**WELWYN HATFIELD BOROUGH COUNCIL
EXECUTIVE DIRECTOR - PLANNING, PUBLIC PROTECTION AND GOVERNANCE**

DELEGATED APPLICATION

Application No: 6/2020/1745/HOUSE
Location: 6 Hill Rise Cuffley Potters Bar EN6 4EE
Proposal: Erection of first floor front extension, alteration of roof form into crown roof, part single part two storey rear extension, alteration of fenestration and insertion of first floor side windows into the western flank elevation wall.
Officer: Mr Antoine Commenville

Recommendation: Granted

Date:	17 Septmeber 2020
Scale:	A1@1:100
Dwg:	030/20 4A
Drawn by:	SA

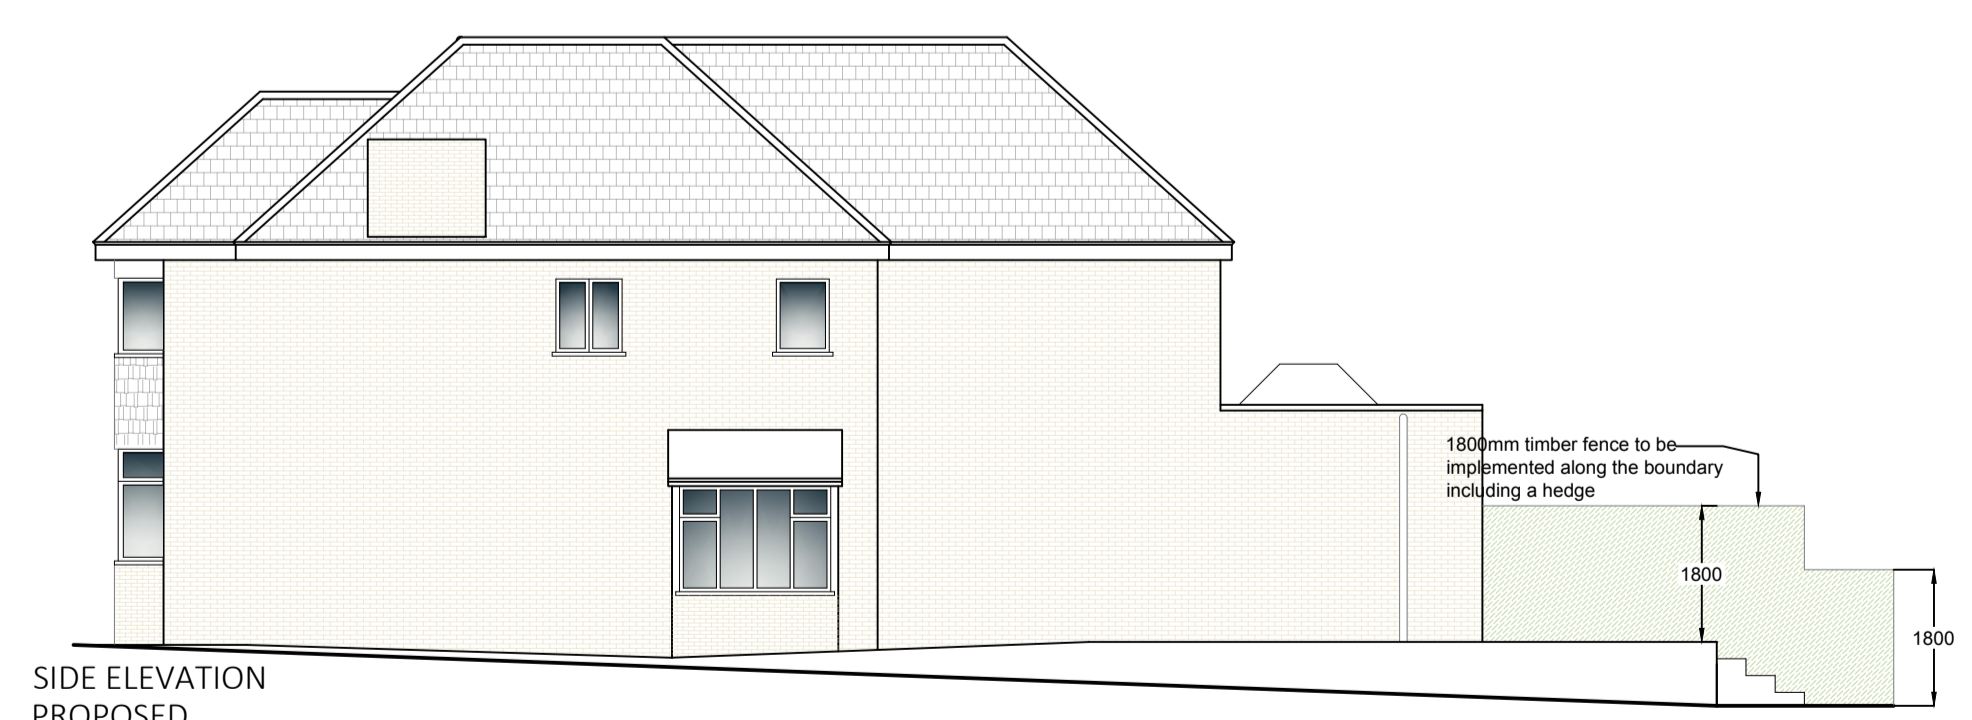
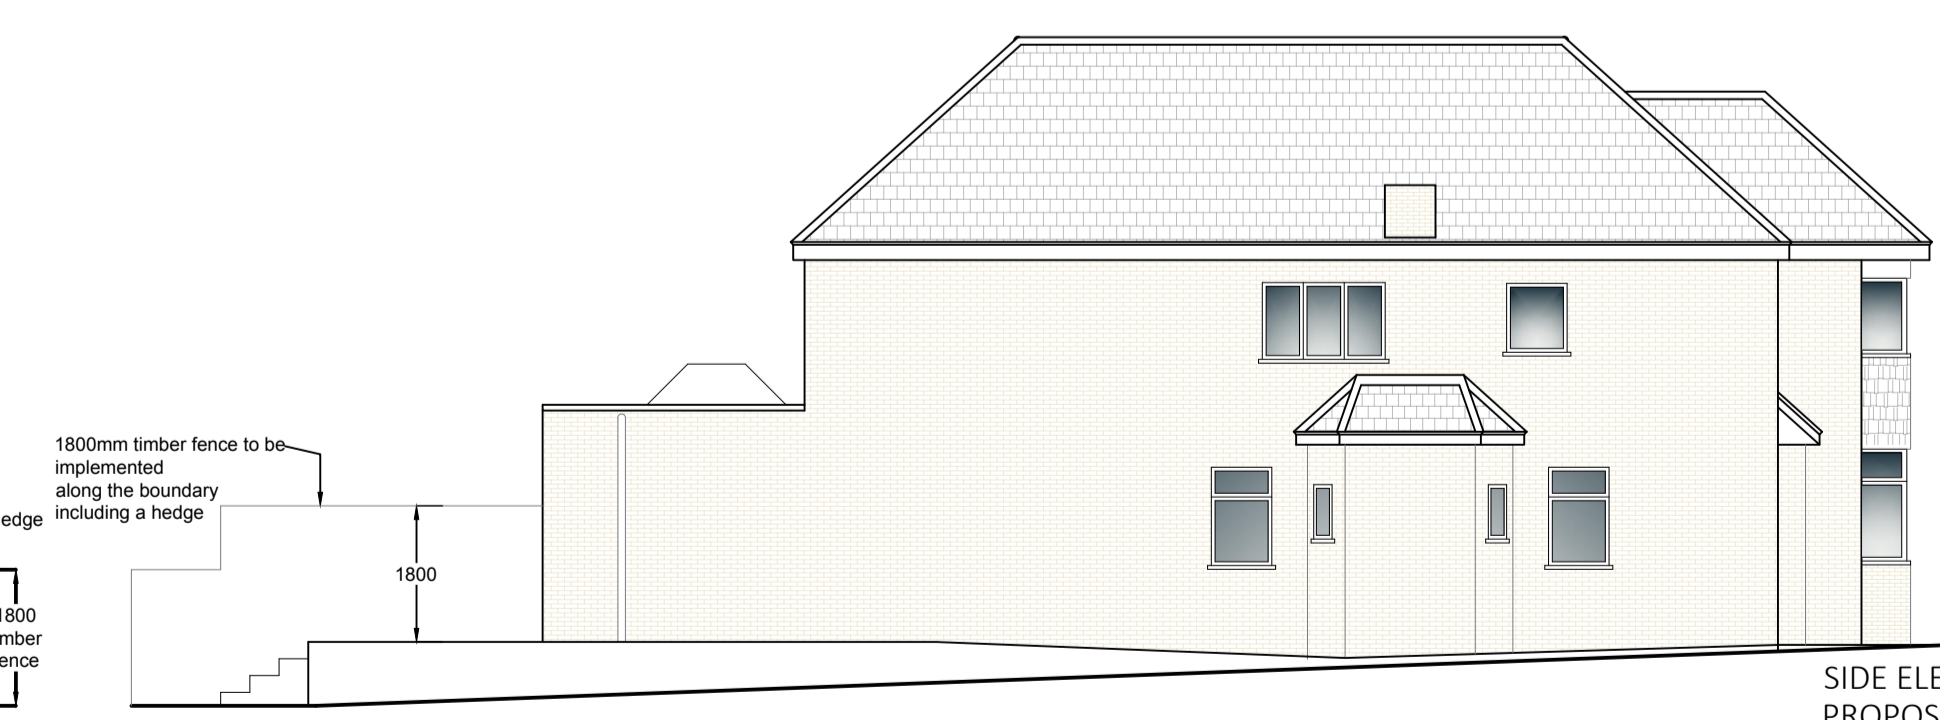
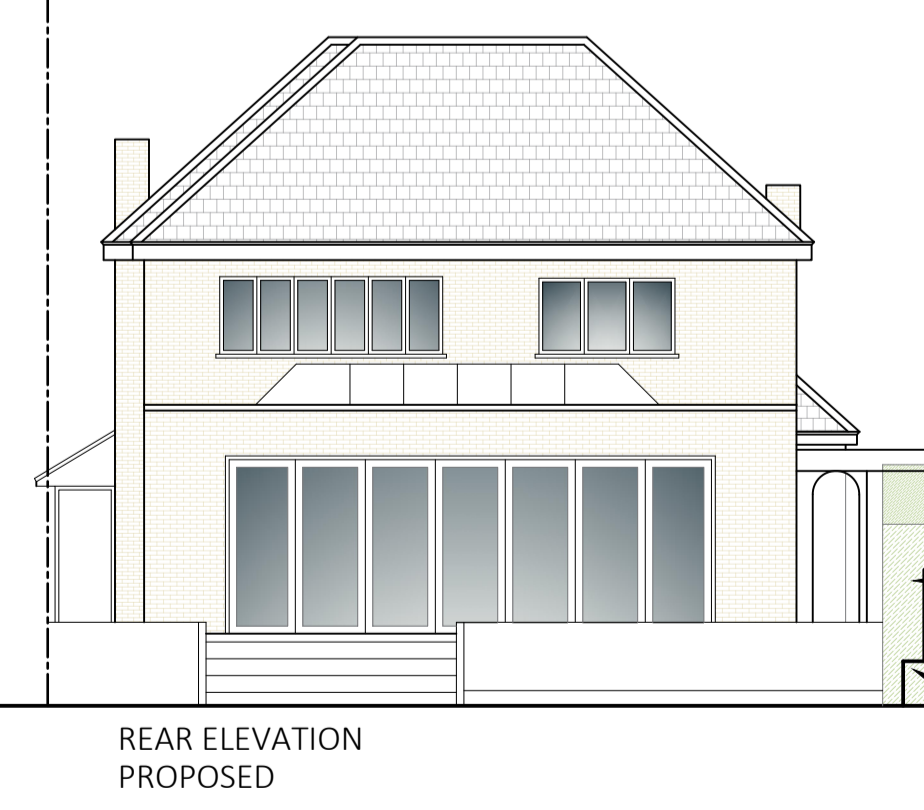
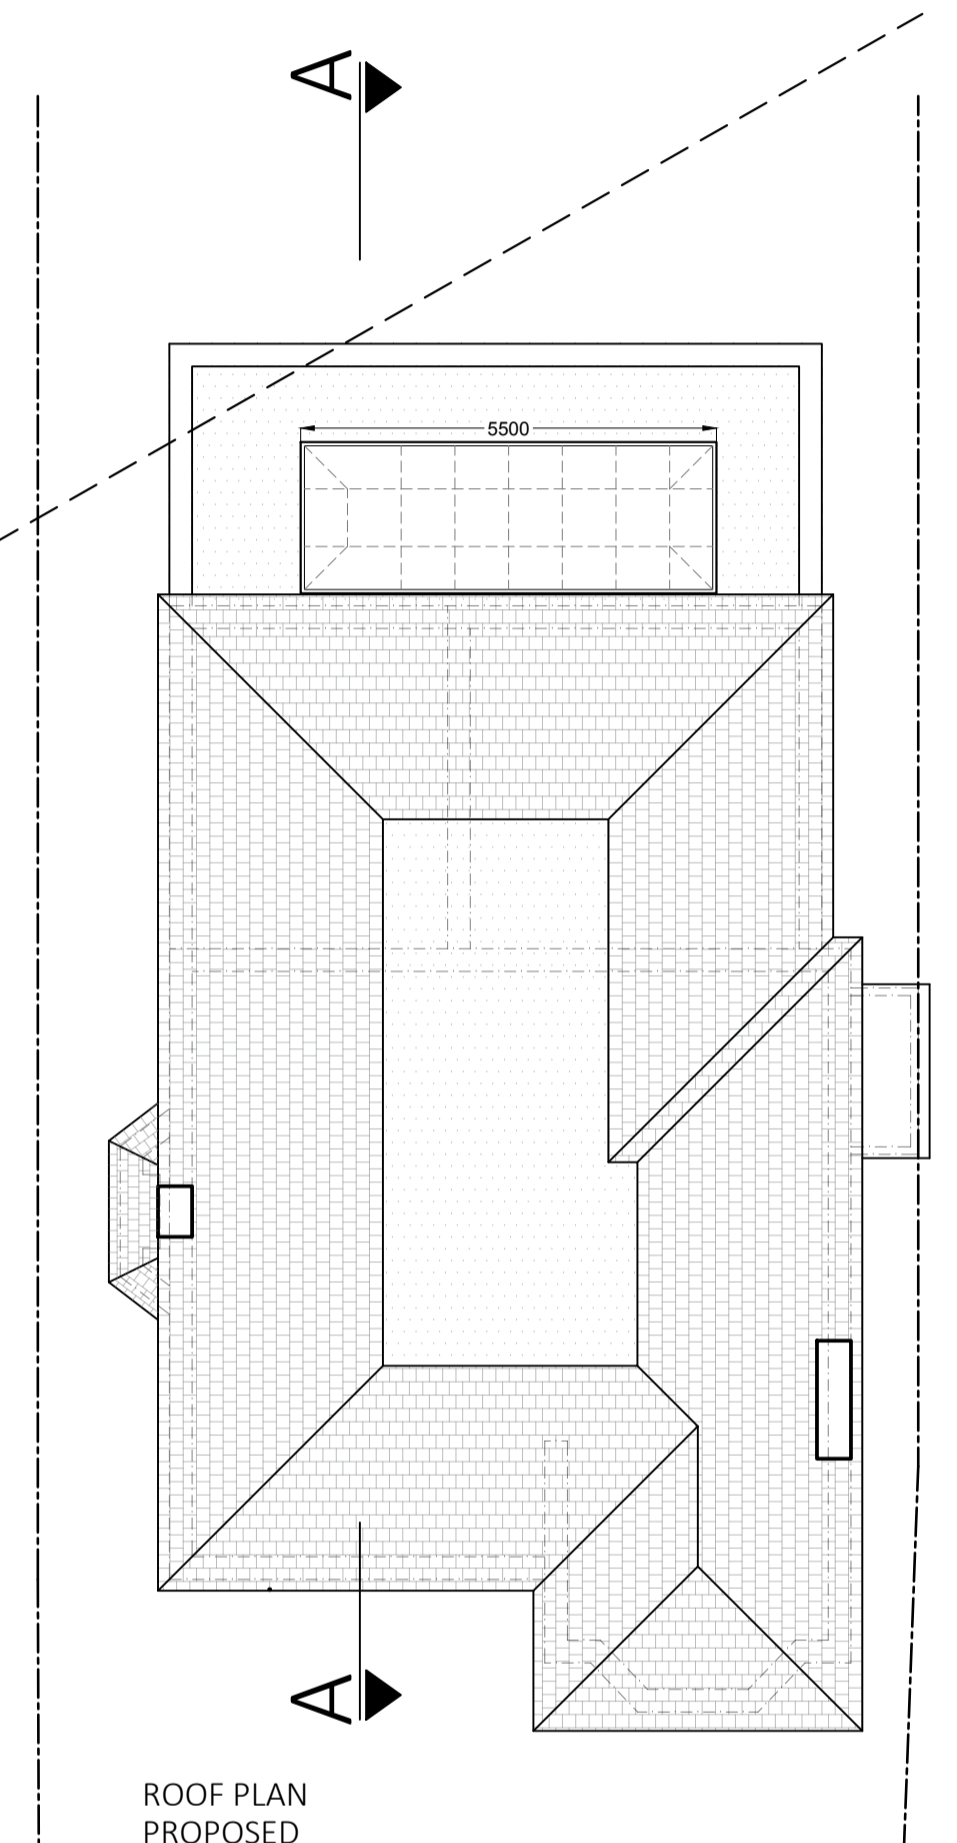
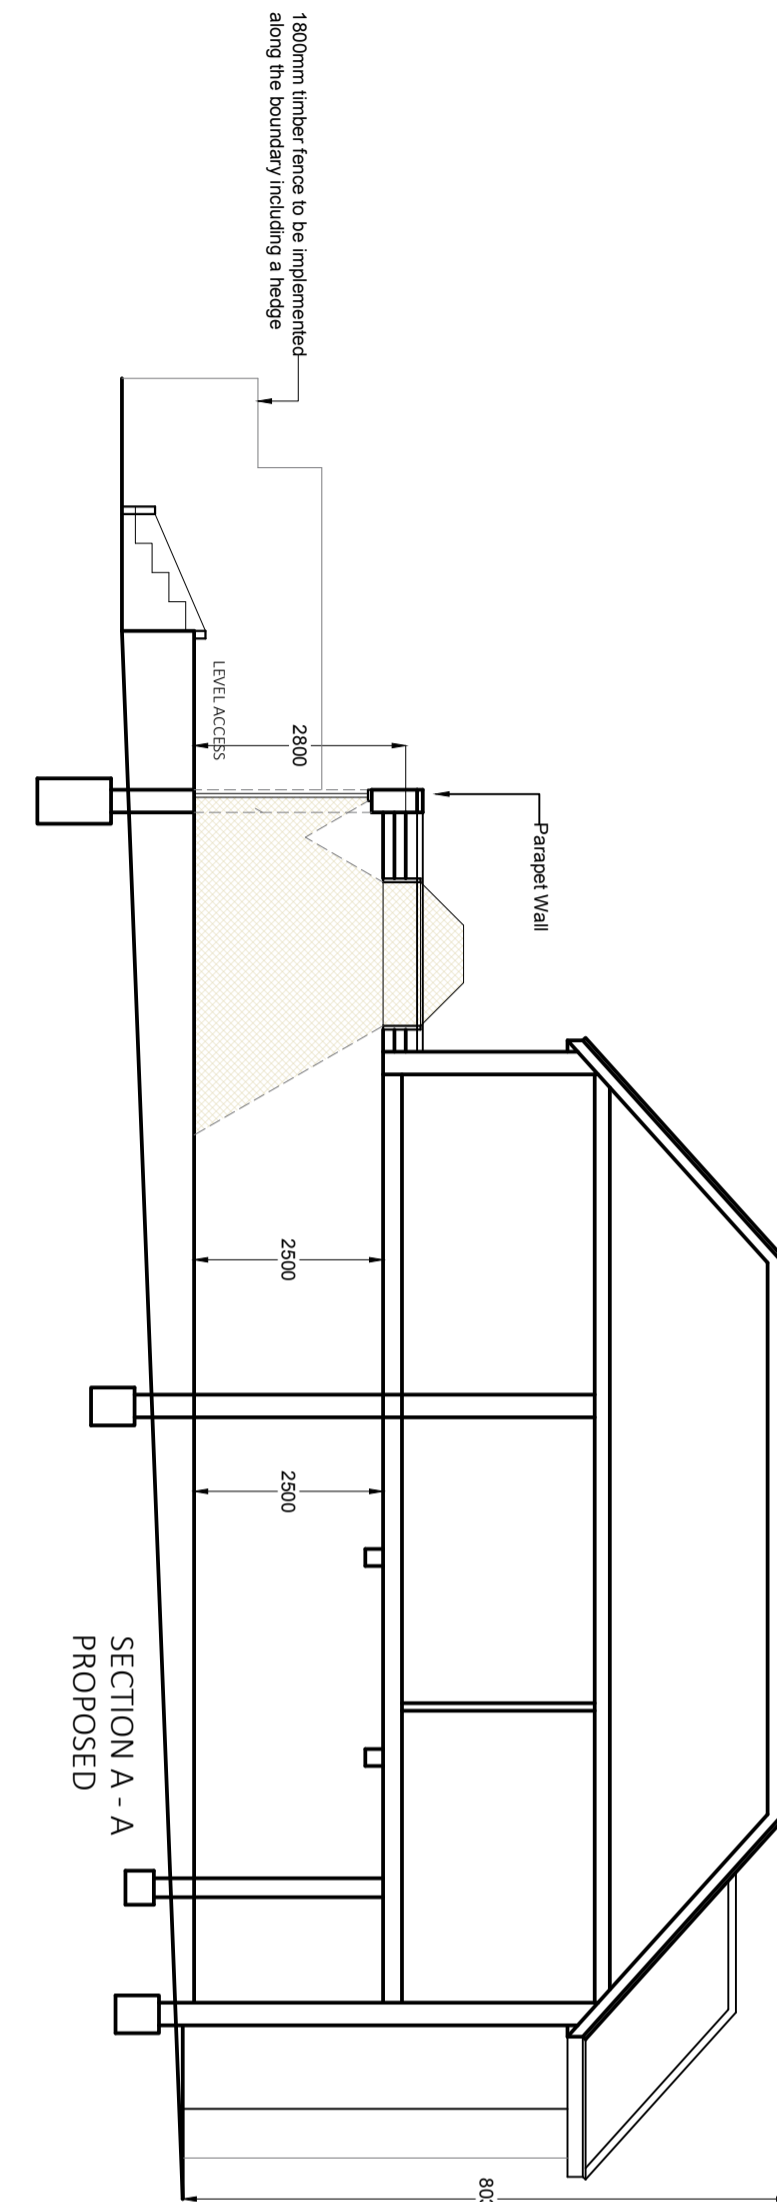
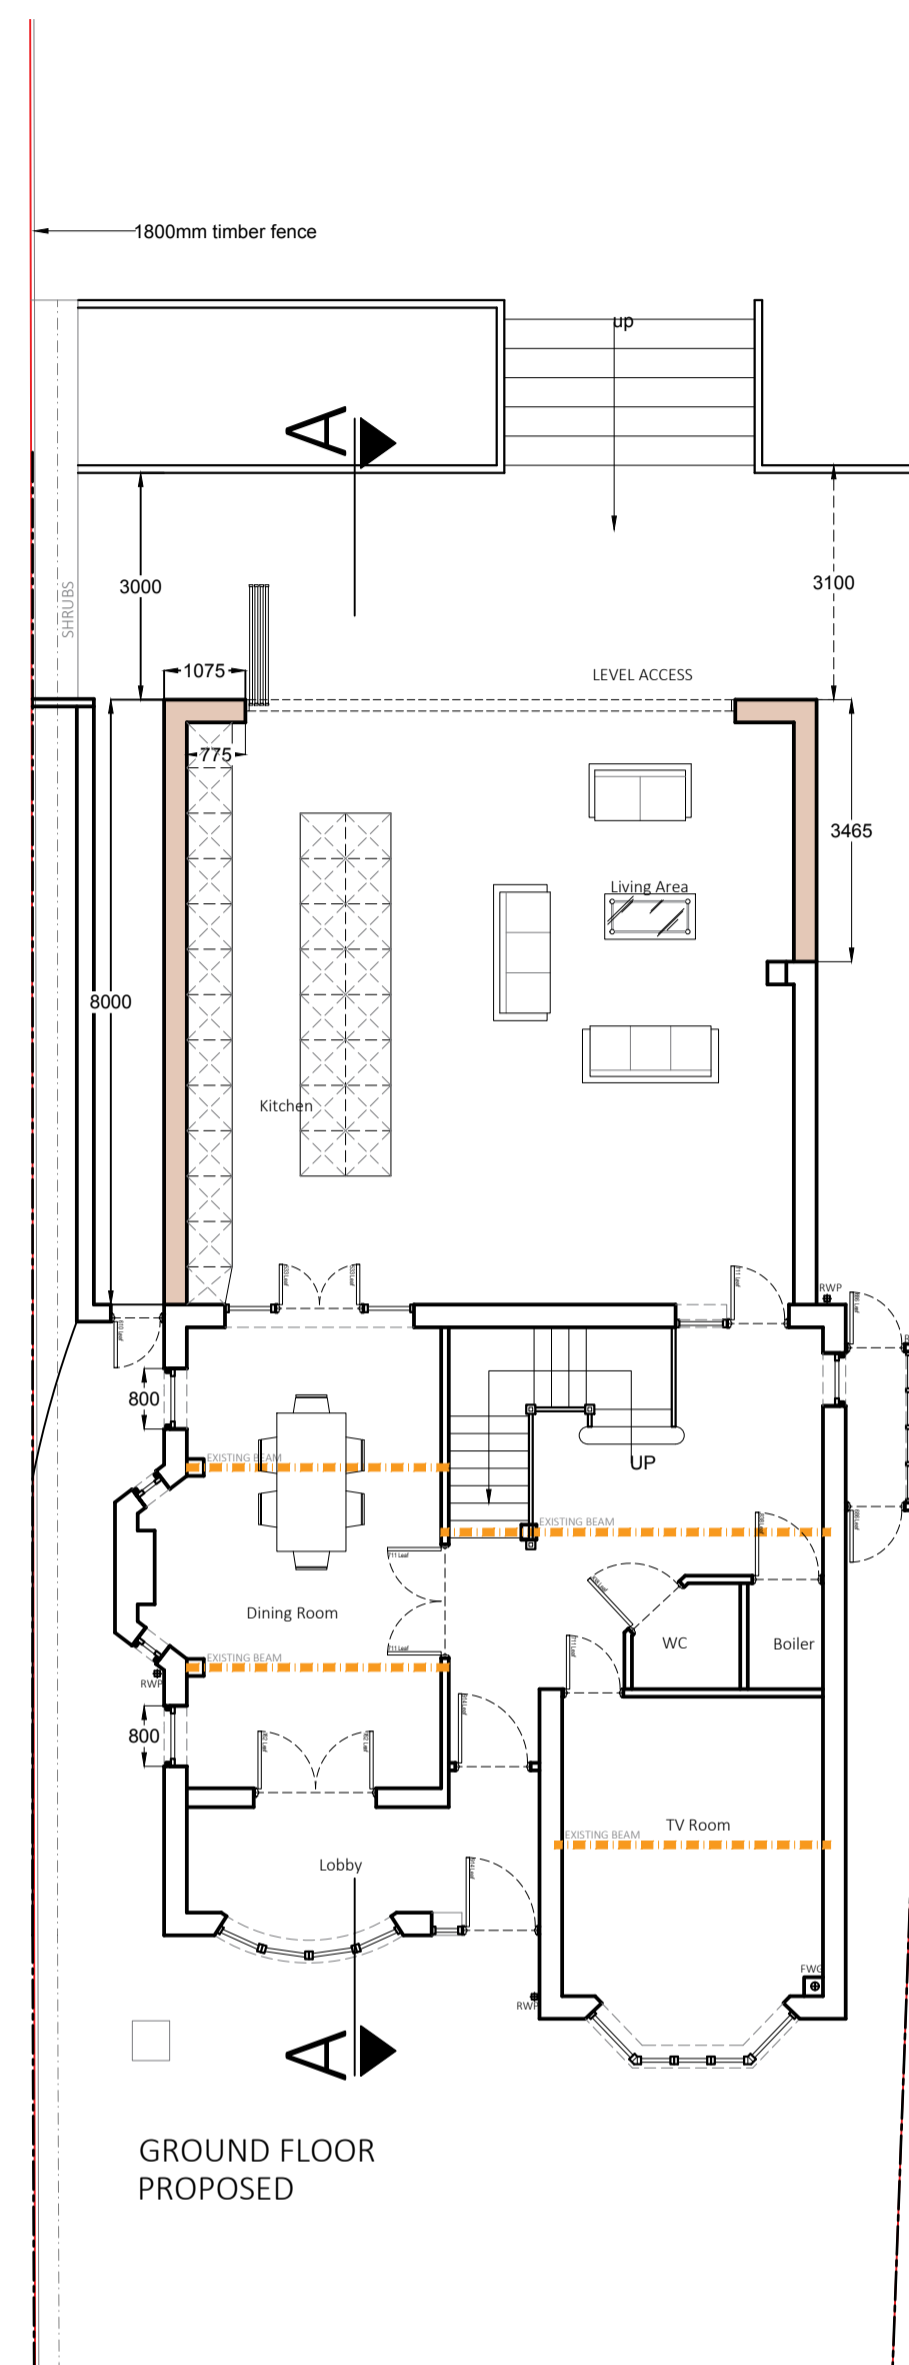
Comment (if applicable): A first floor flank window is proposed to be inserted within the western

flank elevation wall at first floor level and facing No.8. It is considered reasonable to add a condition for this window to be obscure glazed and non-opening below a height of 1.7 metres when measured from internal floor level to ensure that the windows would not result in any overlooking or a loss of privacy to No.8. However, this window is the only window serving this bedroom which is not ideal. However, this would be the only bedroom out of 4 proposed bedrooms to be served with obscured glazing only and it is therefore considered to be acceptable.

An amended drawing has been sent during the course of the application showing a screening between the proposed rear patio and No.8 rear garden. It would be reasonable to condition this fencing is retained in order to protect the residential amenity of the adjoining occupiers.

2. The proposed screening to the shared boundary with No.8 and along the proposed patio shown on drawings 030/20 Rev 4A shall be implemented and shall be retained in that form thereafter.

3. Any upper floor window located in a wall or roof slope forming a side elevation of the building hereby approved must be obscure-glazed and non-opening unless the parts of the window which can be opened are more than 1.7 metres above the floor

of the room in which the window is installed, and shall be retained in that form thereafter.
